PROJECT NO. PR-2019-002671

Application No. SI-2021-00255 and -00256

Memorandum

Re: DRB Comment Responses for PR-2019-002761 (SI-2021-00255 and SI-2021-00256)

A4 DRB SITE PLAN

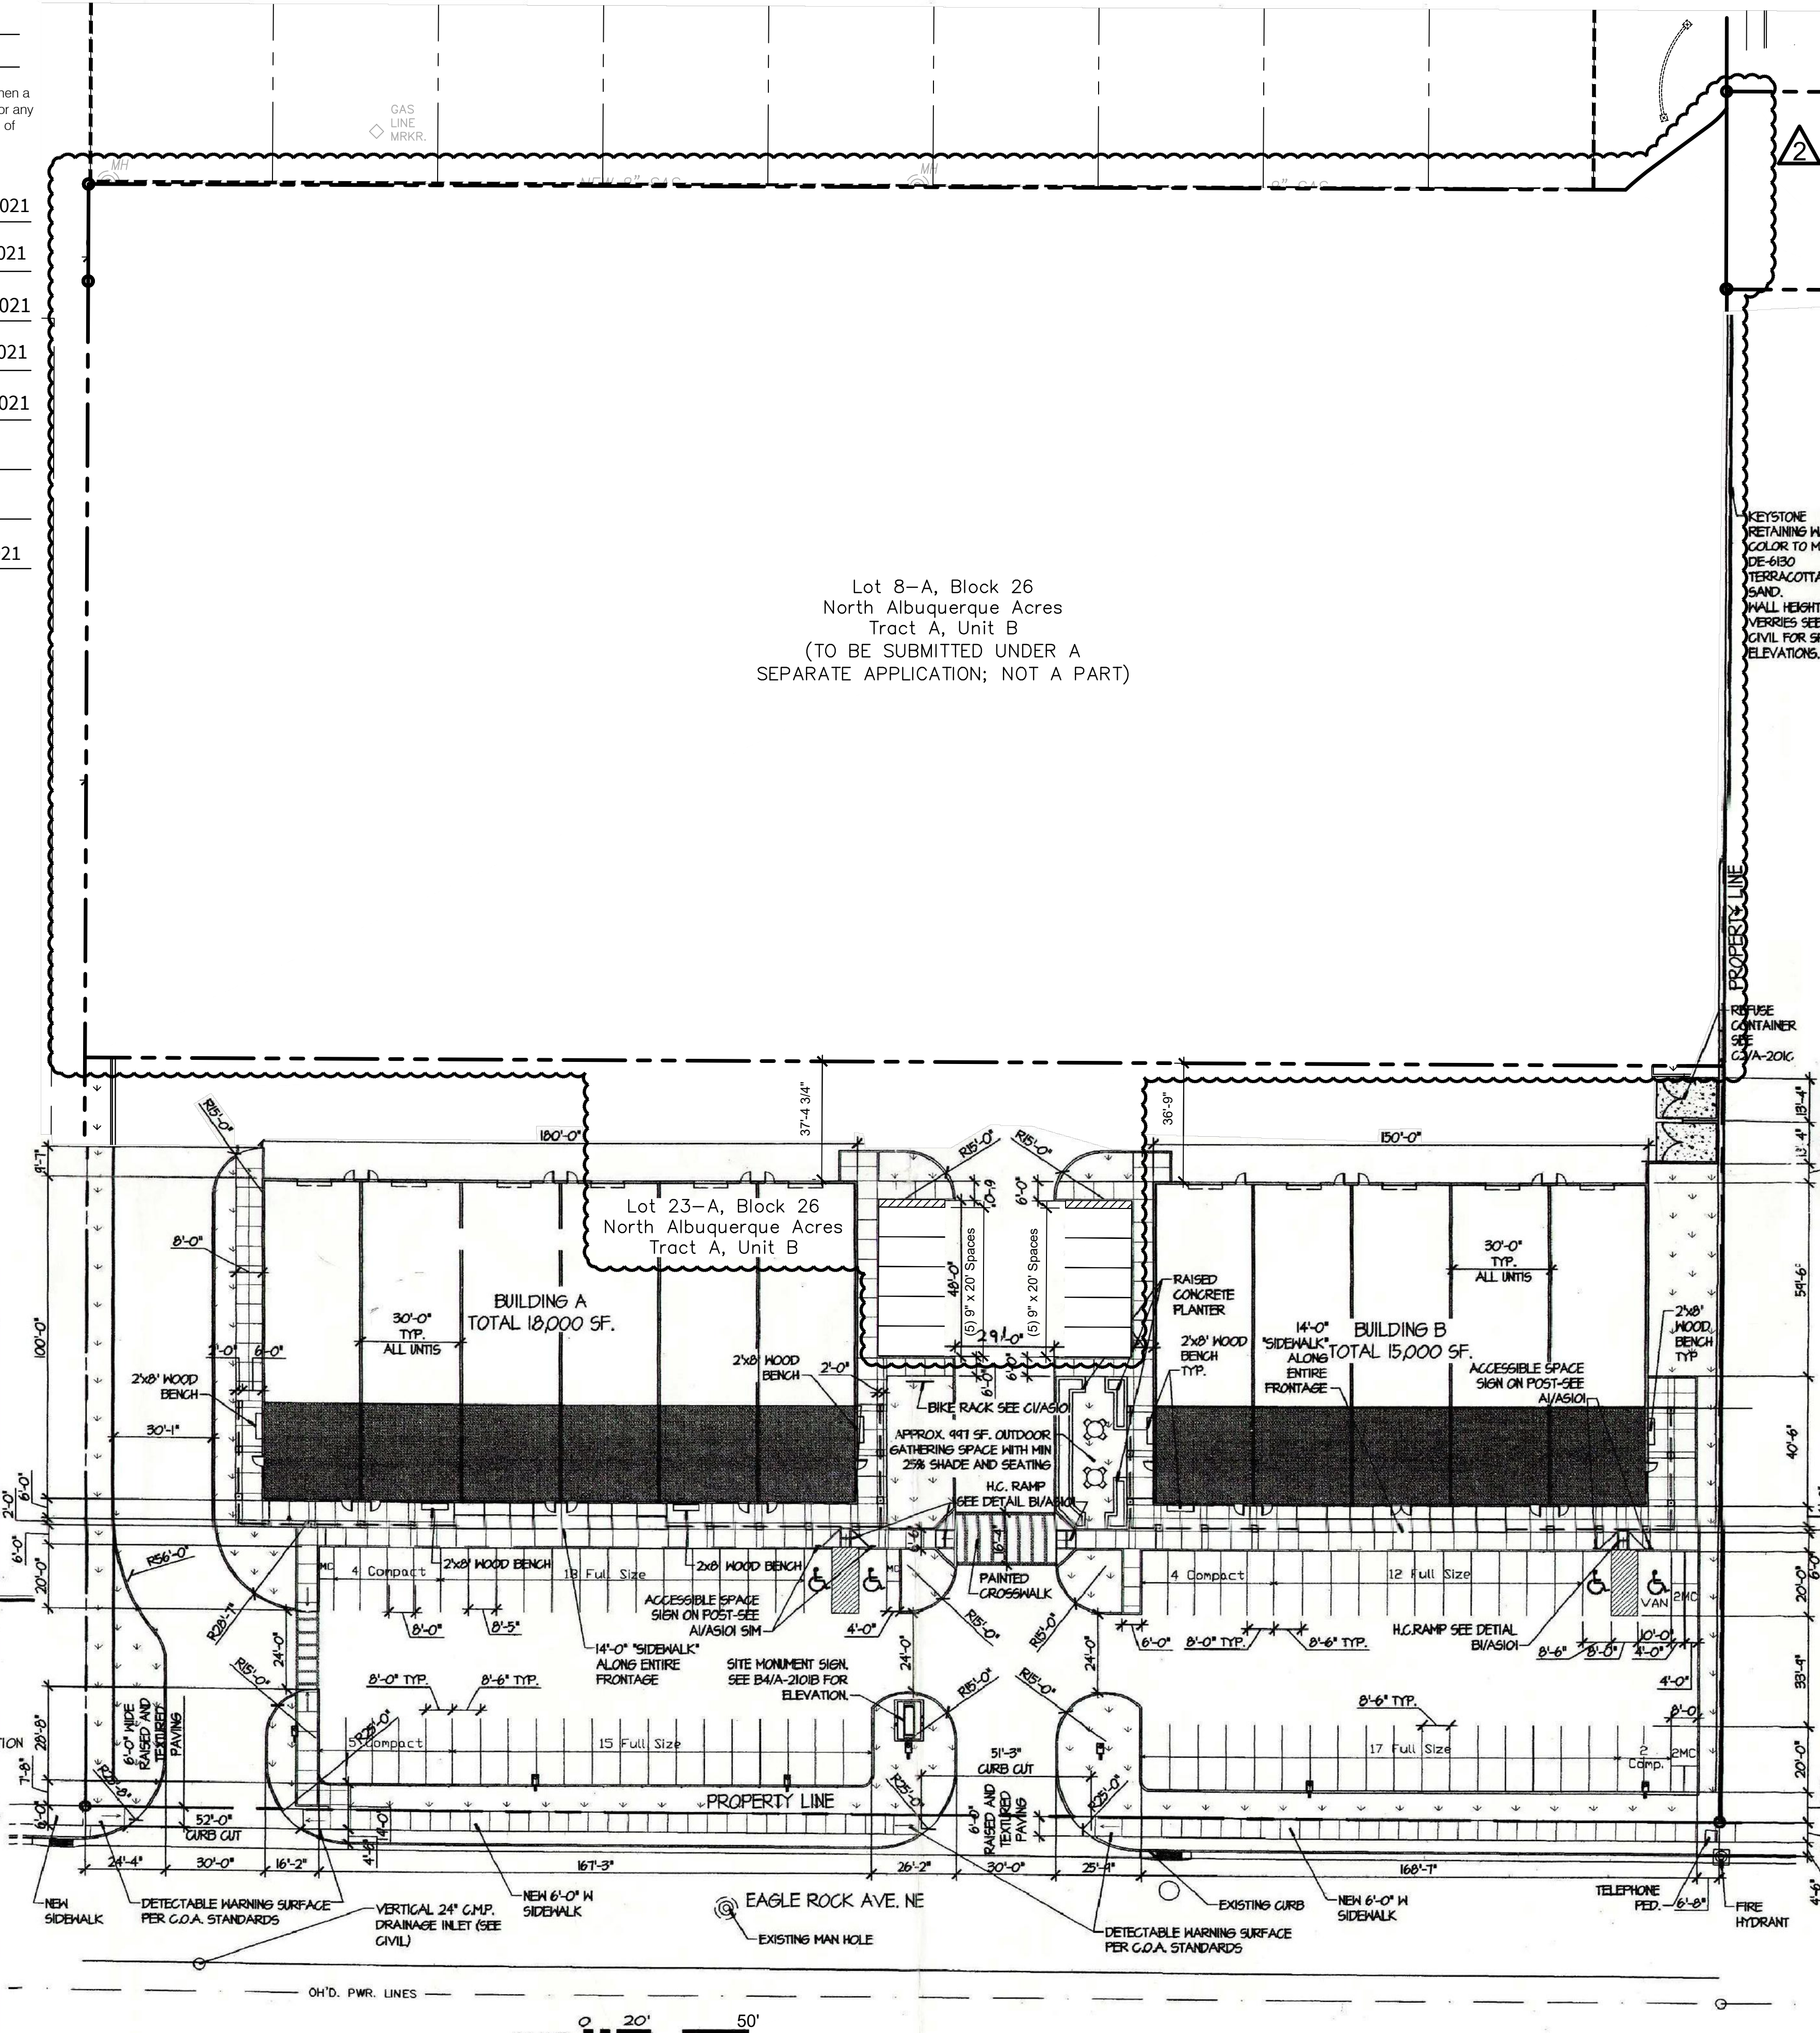
1. The original previously approved Site Plan is included in the application submittal. However, the Amended Site Plan that is subject to review and approval by the DRB is not included in the submittal and must be added.

a. We have reattached the proposed amended site plan to this supplemental submittal. It consists of two sheets, amending the last Minor Amendment that was done to remove Lot 8-A and state it will be approved via separate submittal, as well as delete the building elevation for the building that will no longer be built.

OVERALL UTILITY PLAN

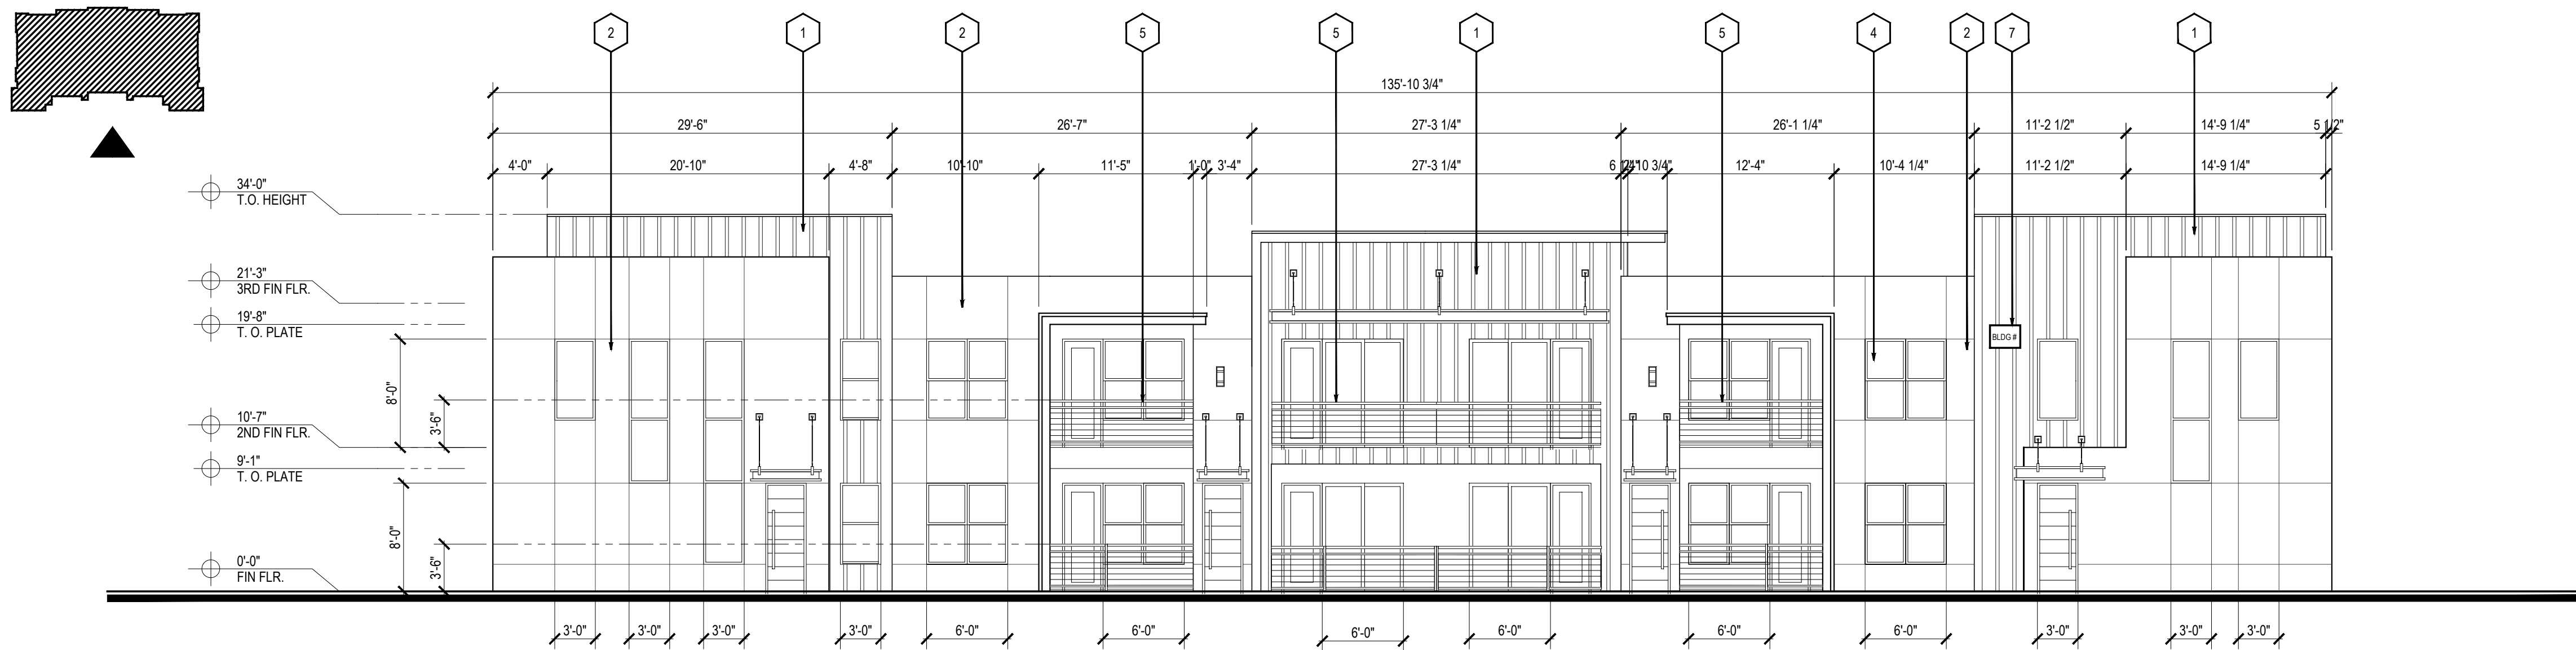
1. Prior to removal of Lot 8A, the service stub outs shall be removed and capped, or such removal be provided for on an infrastructure list for a site plan (SI-2021-00256).

2. The project to the north is reliant upon a sewer main depicted on the remainder portions of this site plan. Please advise as to the existence of that sewer main, when it will be constructed, and how public easement will be provided at the sewer main location as needed for the apartments to connect.

3. Additional public waterline easement appears to be necessary on the remainder tracts for the utility plan for the apartment project to work. Please advise as to the generation of additional public waterline easements on the remainder tracts.

1. The alignment of the relocated public water main requires approval.

It is the preference of ABCWUA for a more direct route on the water main through the site. This can be accomplished by traversing due north then due east. This also reducing the extent of water main to be removed and replaced on the northern parcel line. Please review the alignment and submit a workable alternative for ABCWUA review and approval.

3. The onsite hydrants shall be private and be painted accordingly.

4. Please show public waterline easements on the lot to the south so that we have confirmation that the proposed routing is within an ABCWUA public waterline easement. If one does not exist, acquire one or adjust the alignment.

5. Please show private sewer easement on the lot to the south so that we can confirm there is a viable path for the sewer shown on the utility plan. If one does not exist, acquire one or adjust the alignment.

You may not share private sewer services. Connection to the existing private sewer on the lot to the south is not permissible, and a new private sewer service would have to be constructed to direct flows to the south.

Alternatively, you may connect to sewer at the northeast of the site on Modesto.

- a. **The removal of the existing line and related service stubs and associated infrastructure is included in the updated infrastructure list, which is attached, as well as shown via Keyed Note 6 on the utility plan.**

- a. **The utility plan for the project to the north has been revised to show a separate private sewer line. The existing easements upon this property provide for the ability to install underground utilities for the benefit of the northern property across the southern property (see attached).**

- a. **The Site Utility Plan has been updated to indicate a proposed public waterline easement to be granted by paper document.**

- a. **This comment has been discussed with staff. The proposed location of the waterline is happening along with the relocation of gas lines away from the northern edge of the property, which allows for the planting of trees and other landscaping to create a**

buffer to the subdivision to the north. In addition, carport structures are being installed as well, so these lines need to be relocated to the drive aisles, which are open and away from each other.

a. This has been noted on the revised utility plan.

a. A proposed waterline easement has been identified, which will be granted by paper document.

a. A new, separate private sewer line is now proposed on the utility plan, directing flows to the south.

**A4.11**

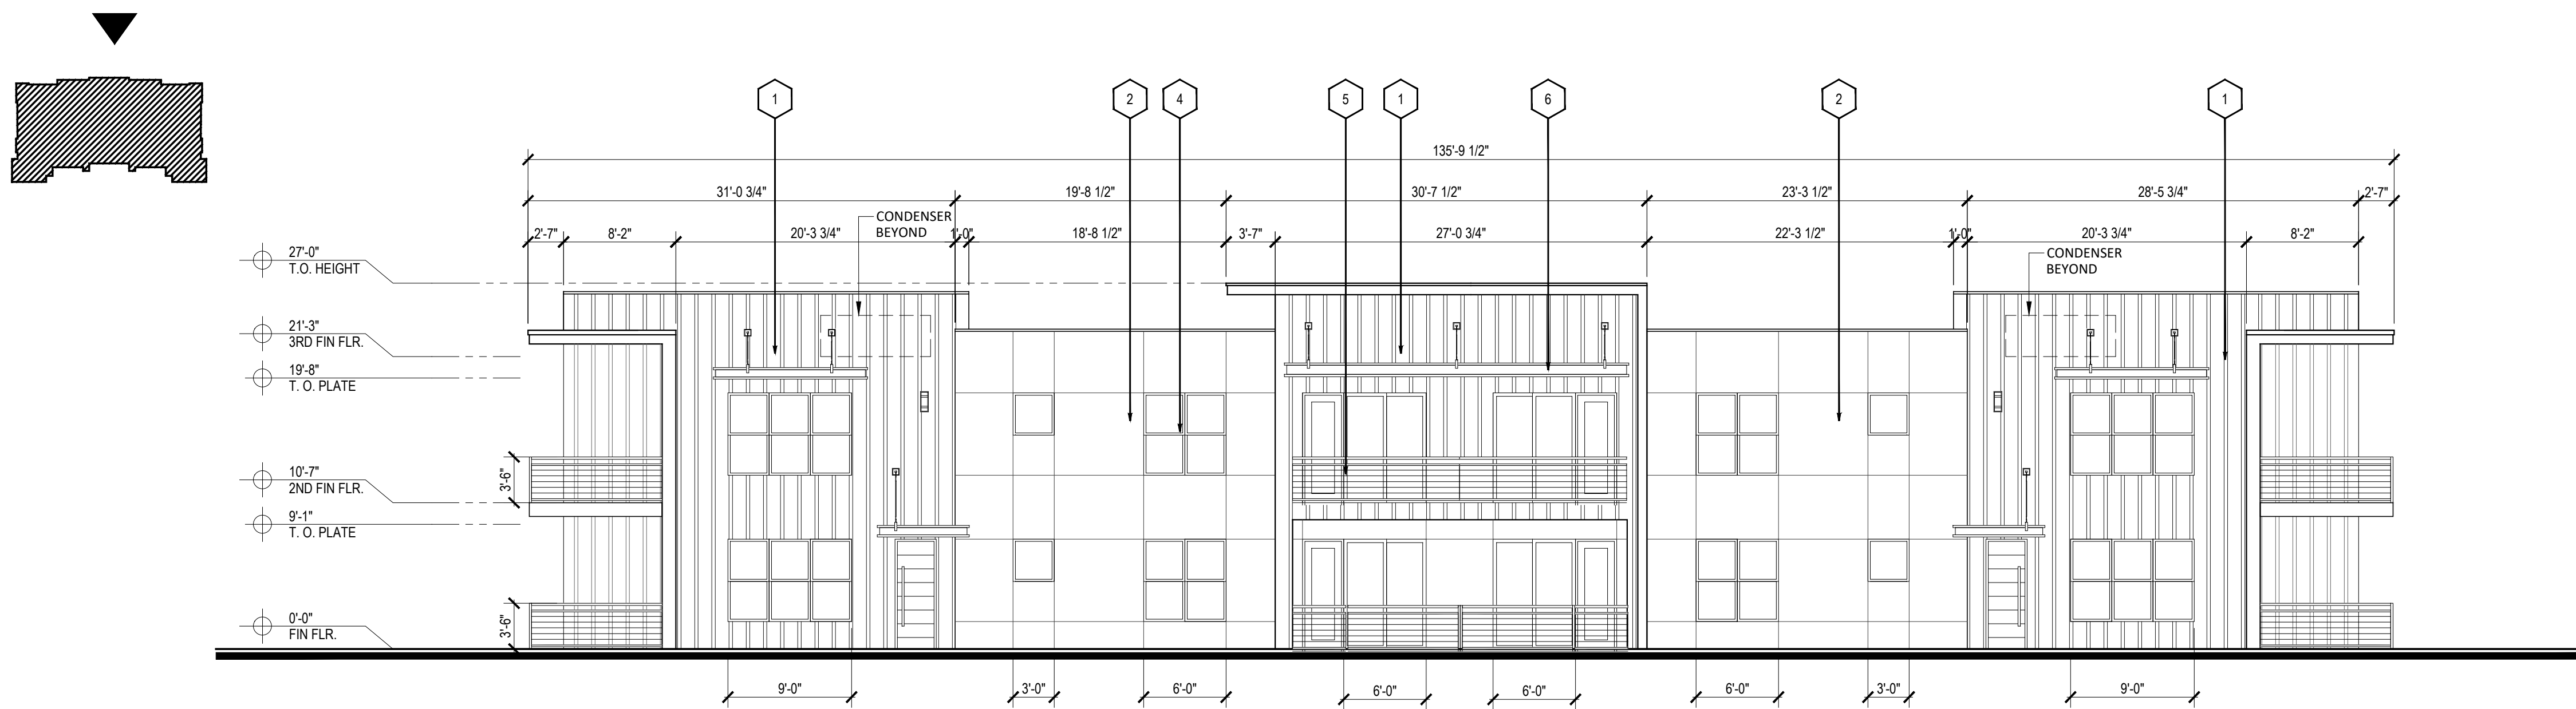
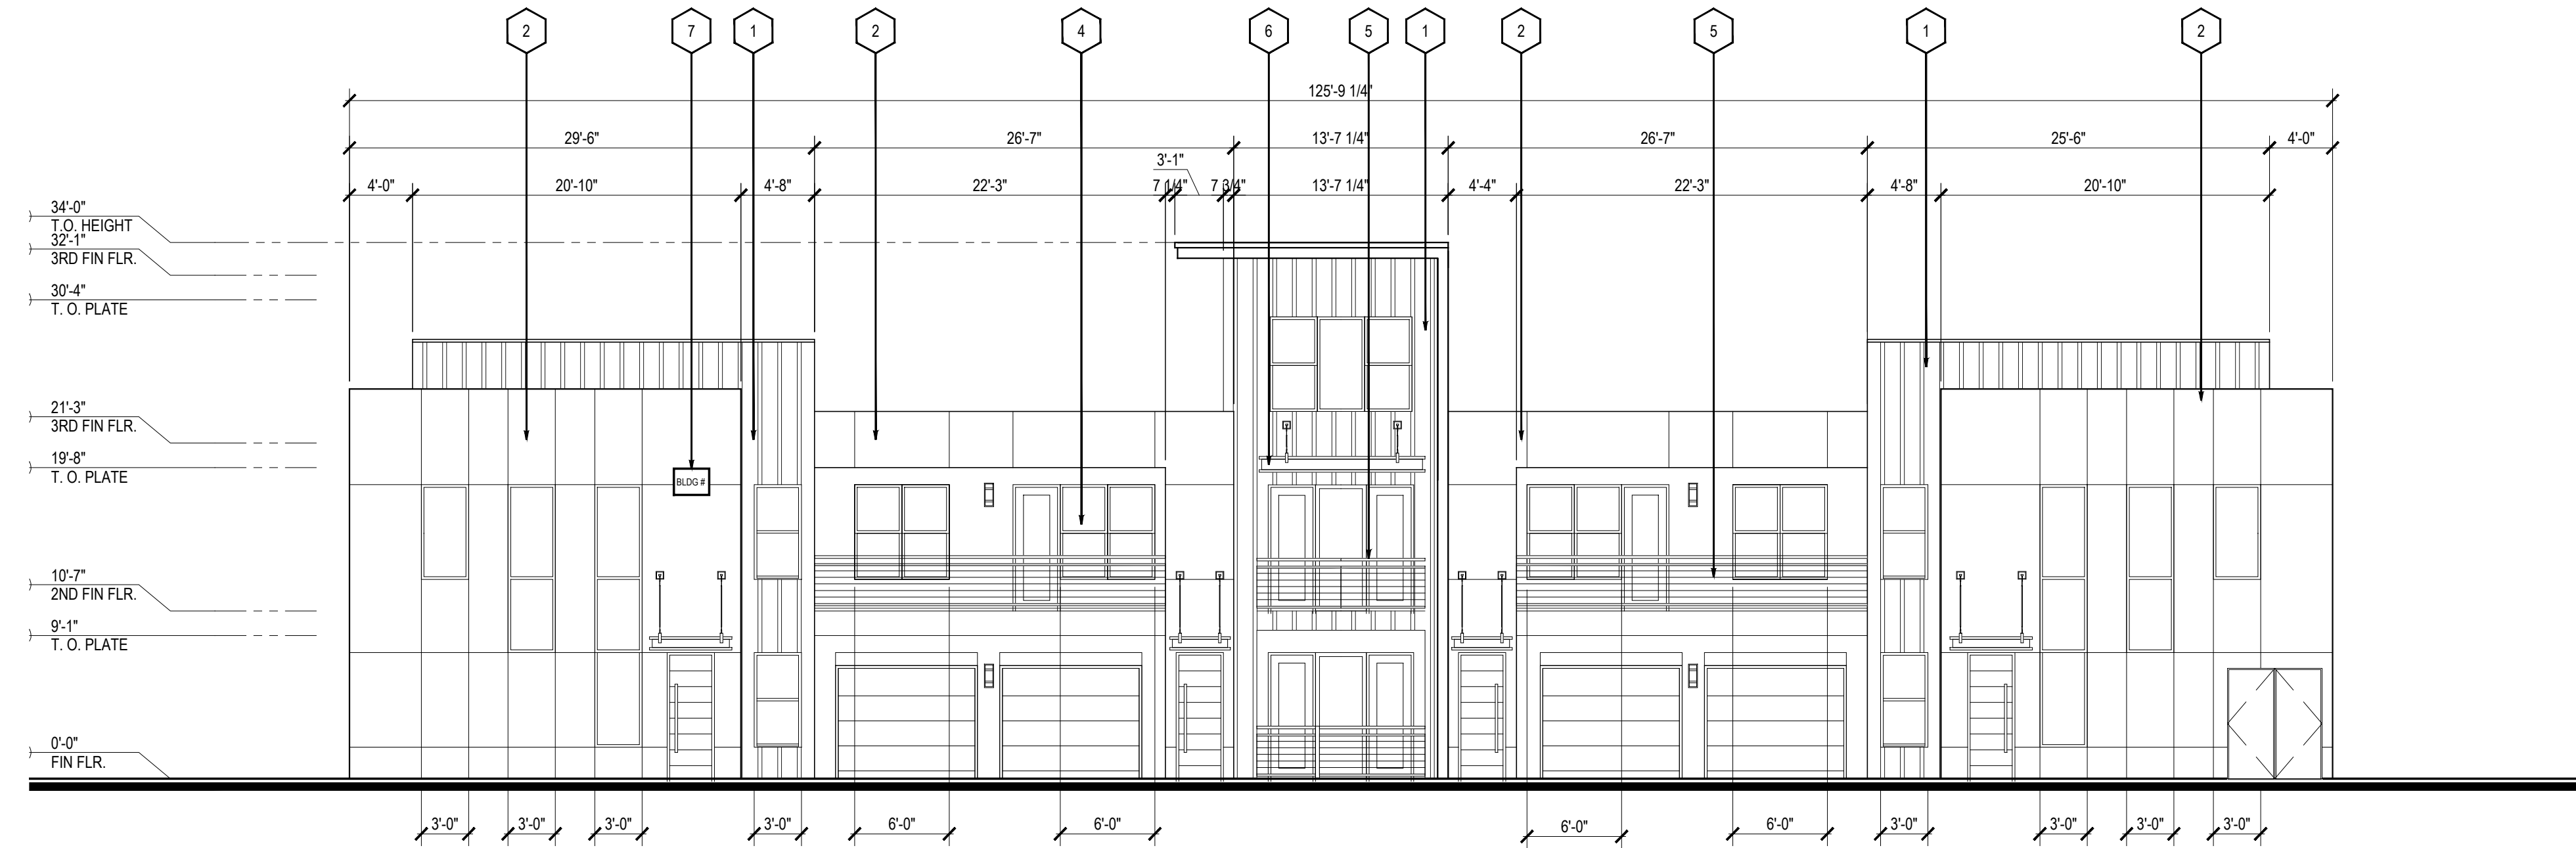
zoned R-1A along the eastern boundary of the property. The Neighborhood Edge provisions of 5-9 of the IDO must be met along the eastern boundary of the property, including the portion of Building 1. Per 5-9(C), buildings within 100 feet of the nearest protected lot must step down to a maximum of 30 feet. Portions of Building 1 at 34-feet in height are taller than the maximum-permitted 30 feet height limit of 5-9(C).

10. Specify how the Façade Design requirements of 5-11(E)(2)(a) are being met in a comment response letter and/or on the Site Plan.
 - a. 5-11(E)(2)(a) regulates building design for street-facing facades. The only facades within the proposed development that are street-facing are the north elevations of Building Type I (left) and the Clubhouse (right).***

- a. This building is a two-story building and only has a height of 27 feet, but one elevation incorrectly labeled it with the same height as the three-story buildings. This has been corrected.***

The north side of Building Type 1 includes a primary building entrance and several patio entrances facing toward Modesto. The upper floor patios and awning over the building entrance create a horizontal break to the building mass that makes the ground level a more human scale. There are 27 linear feet of ground floor windows, as well as upper floor windows and awnings along a total façade length of a little more than 73 feet or about 37%. No more than the maximum 40 feet is between any distinct feature.
